Advice to the local planning authority

To LPA	Kirklees Council
LPA planning ref no	2022/62/93932/W
Our ref	pgo-2889
Site address	Crown House, 12, Southgate, Huddersfield, HD1 1DE
Proposal description	Change of use of Crown House to provide student-only living accommodation (sui generis) in the form of studios (198), with ancillary concierge and communal facilities including an open plan lounge, coffee bar and gym at groundfloor, with laundry, car parking, cycle store, parcel store and plant rooms at basement level and associated works including the installation of new cladding and fenestration to the elevations with a new roof garden atop the building
Date on fire statement	27/11/2022
Date consultation received	27/02/2023
Date response sent	27/03/2023

1.1. The above consultation relates to a proposed student accommodation block with a storey height of 35.3m served by two staircases.

Bin Store Front Elevation
1 : 50

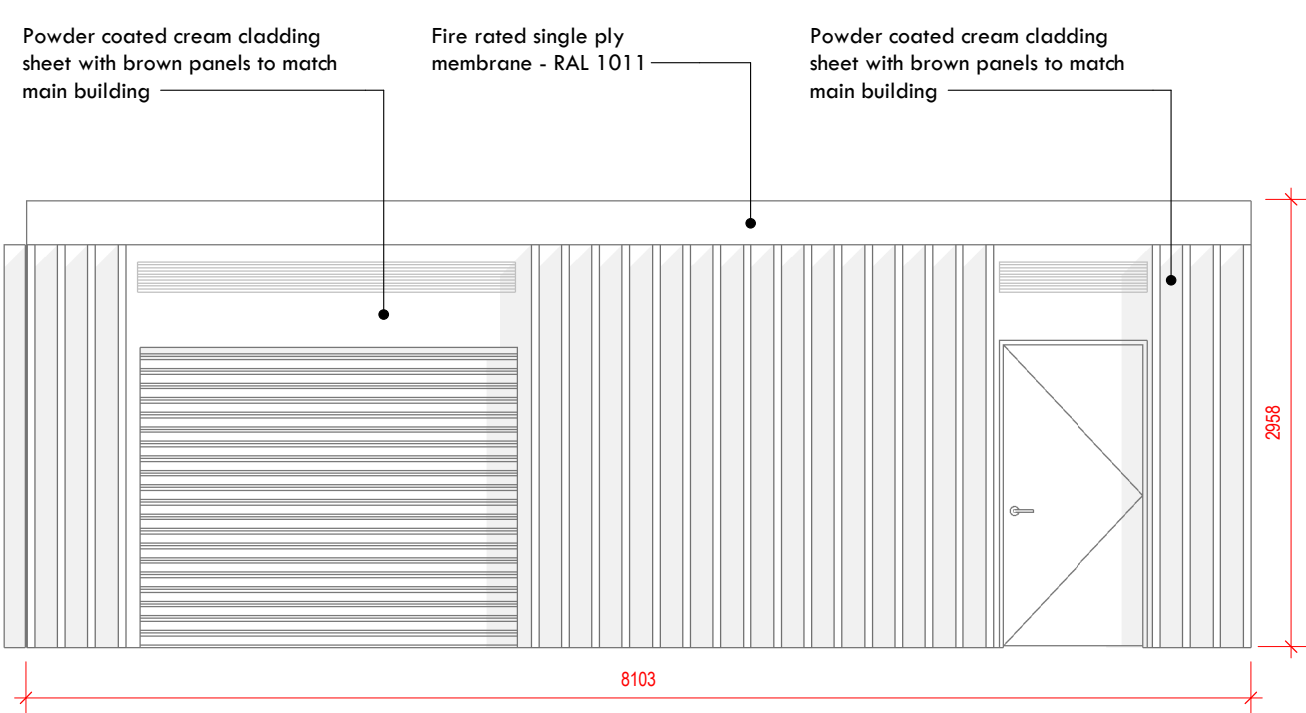
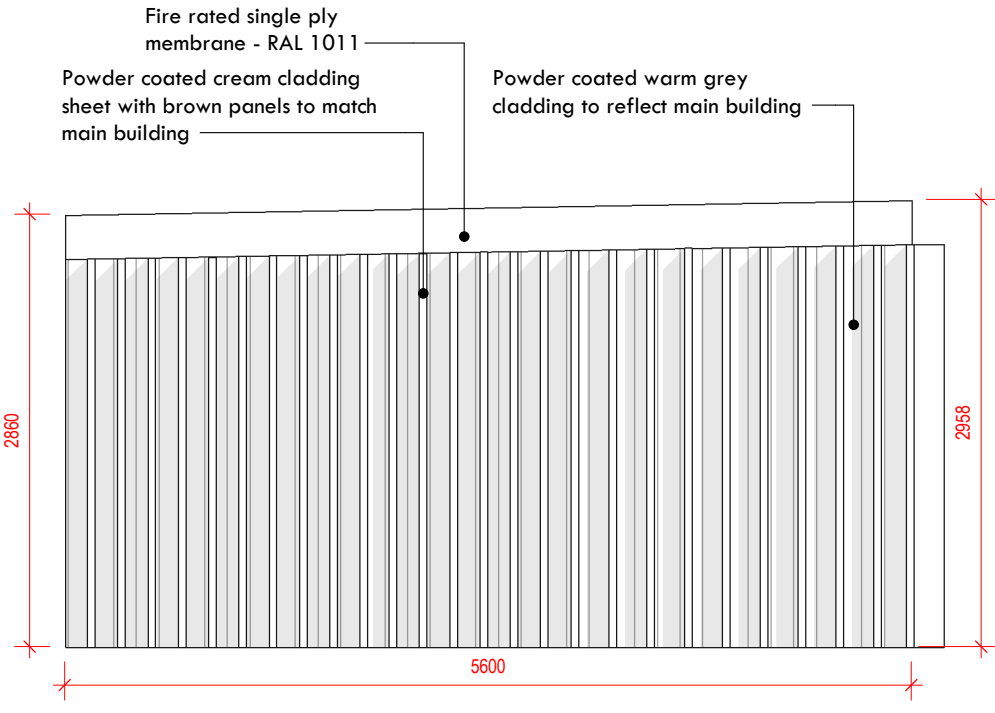
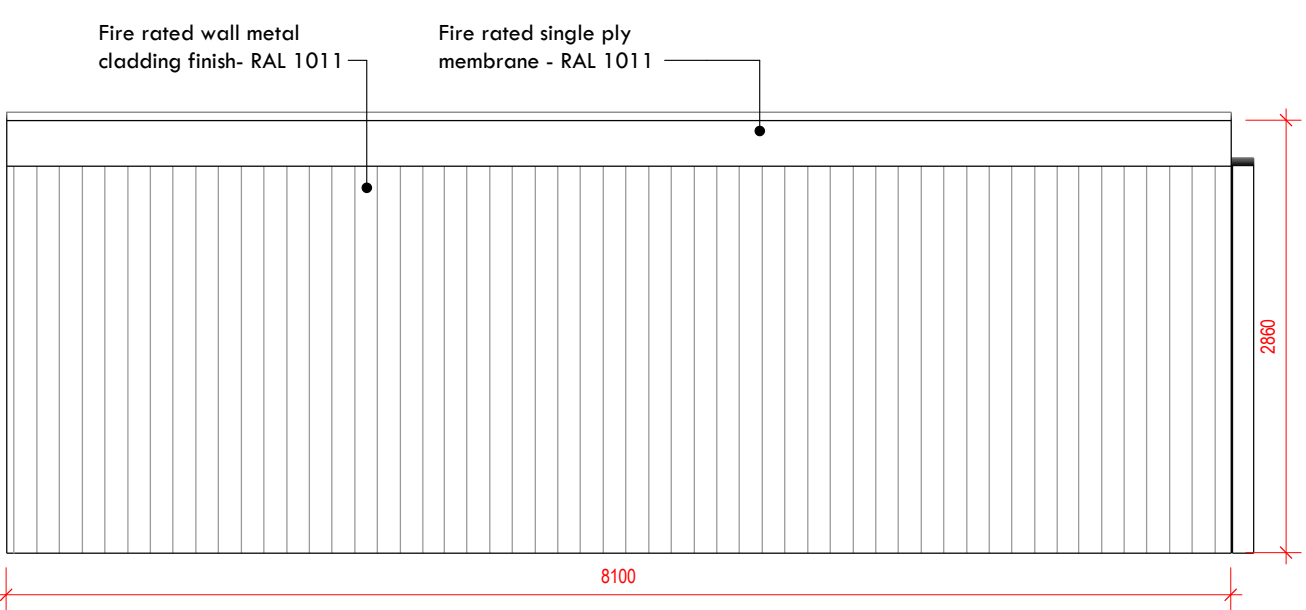
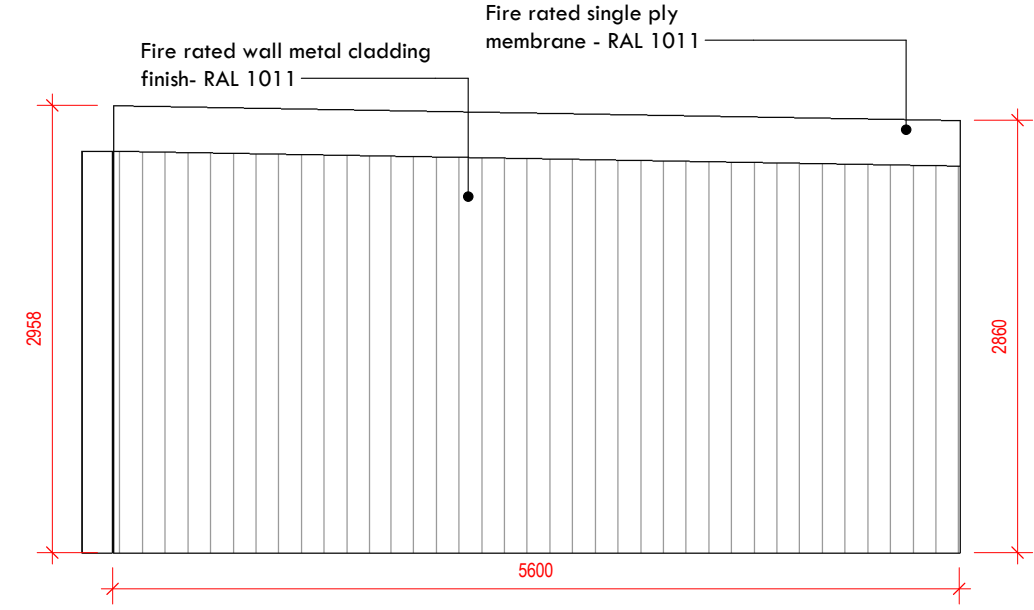
1.4. Drawings show an external bin store compound immediately adjacent to the building, and directly below a flat window. This poses a risk of fire spread from the bin store to the building via the windows. Design changes necessary to resolve this issue will affect land use planning considerations such as landscaping, layout and appearance of the development.
